SSD 6011 - Mixed use residential development within the South West Plot

Submission by:

Michelle Hu and Ken Yu

30 July 2013

## Winter Solstice (21<sup>st</sup> June)

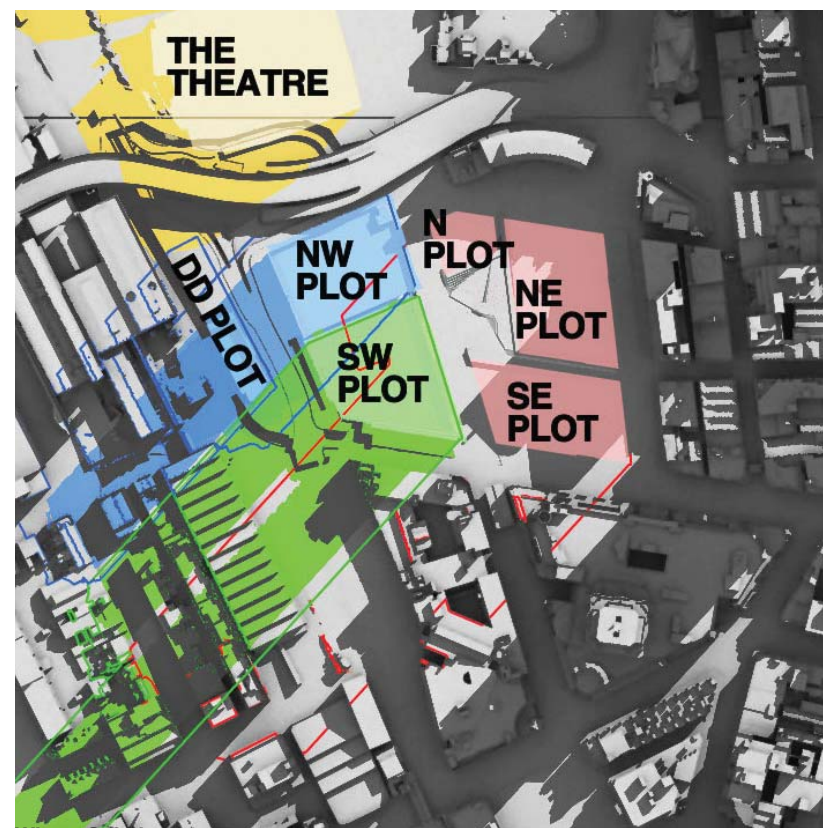
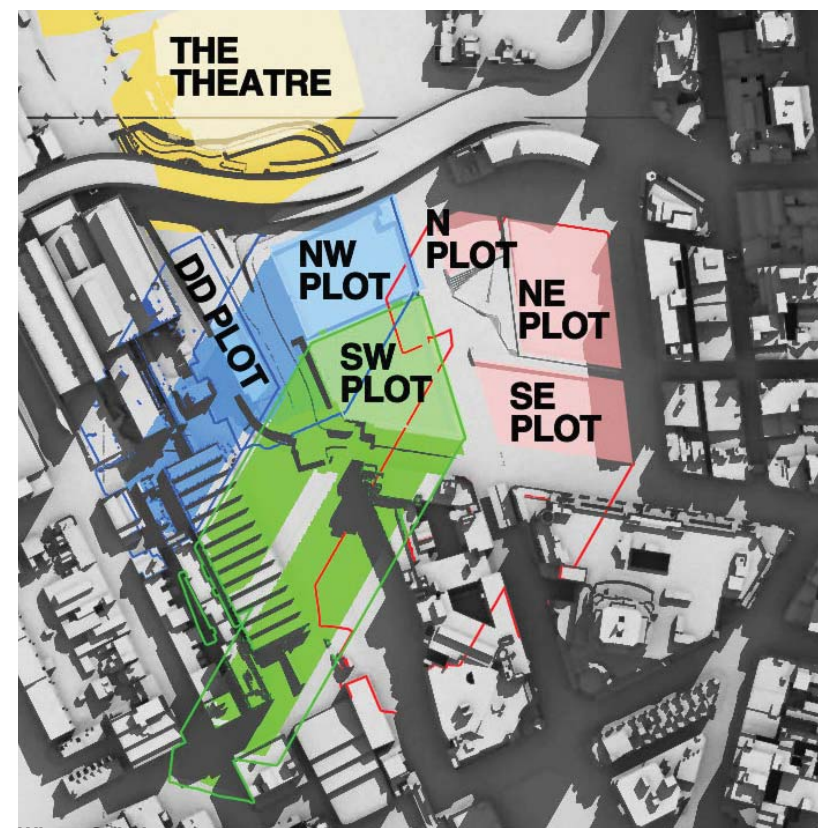
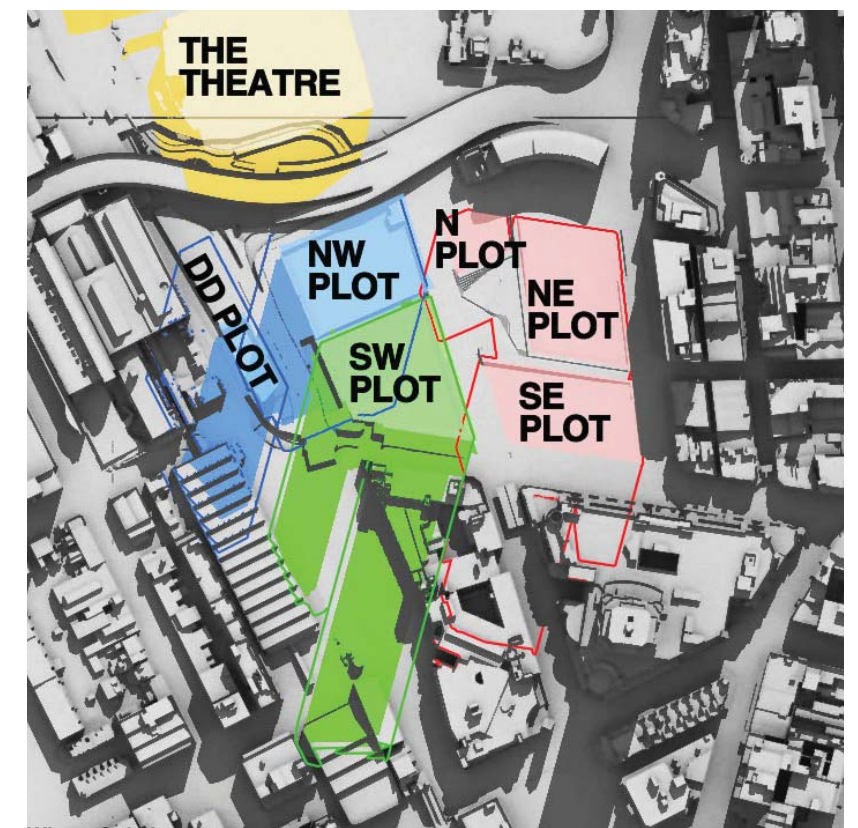
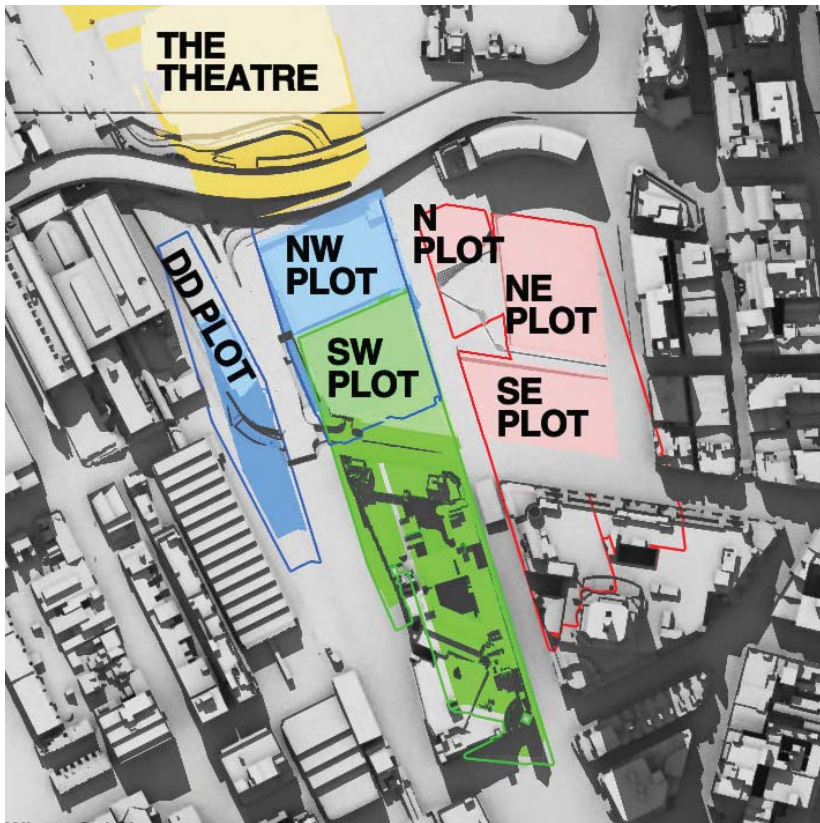
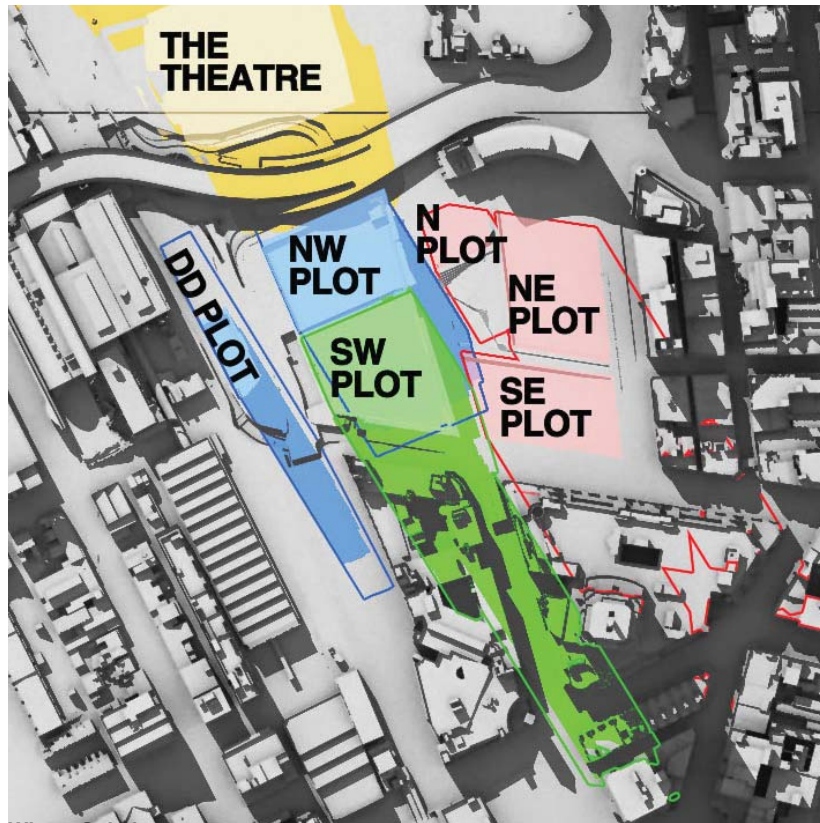
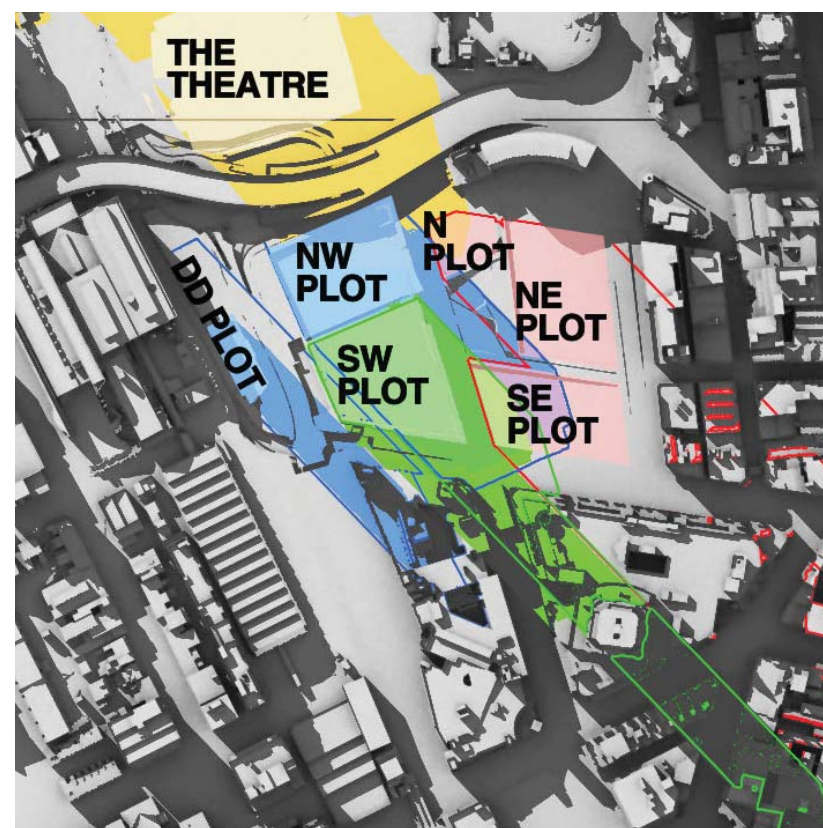
We refer to the shadow diagrams in SSD5878, Appendix H. Supplementary Design Report, Section 6. Amendments, Winter solstice - 22 June. This is not 21 June, but there would be no noticeable difference.

At 9am, 10am and 11am the west façade is totally in shadow due to other parts of The Peak building itself.

At 12pm there is still substantial existing shadowing on the west façade caused by the irregular shape of the west facade.

At 1pm the existing shadowing has been substantially removed, but not totally removed.

It can be concluded that some single aspect apartments on the west façade and some south-west dual aspect corner apartments currently receive less than 2 hours direct sunlight to habitable rooms and 50% of the private open space between 9am and 3pm on 21 June.

By 2pm the existing shadowing has been totally removed, but that is too late to achieve two hours of direct sunlight before 3pm.

At 9am, 10am and 11am the west façade is totally in shadow due to other parts of The Peak building itself.

At 12pm there is still substantial existing shadowing on the west façade caused by the irregular shape of the west facade.

At 1pm the existing shadowing has been substantially, although not entirely, removed. However, overshadowing of lower levels of the west façade by the concept proposal parameter plan shadows for the N,NE and SE plots has already started.

By 2pm the existing shadowing has been totally removed. However, overshadowing of the west façade by the SSDA4 and SSDA5 buildings has appeared and risen further up the west façade than the concept proposal parameter plan shadows for the N,NE and SE plots, which is still present.

At 3pm, the proponent states correctly that 45-45% of the western façade is overshadowed by the SSDA4 and SSDA5 buildings.

It can be concluded that, as a result of combination of the proposed development with existing shadowing of the west façade, some single aspect apartments on the west façade and the south-west dual aspect corner apartments which currently receive less than 2 hours direct sunlight to habitable rooms and 50% of the private open space between 9am and 3pm on 21 June will suffer additional overshadowing. It is beyond our skills to count the number of such apartments. We note that the proponent has made no attempt to do so.
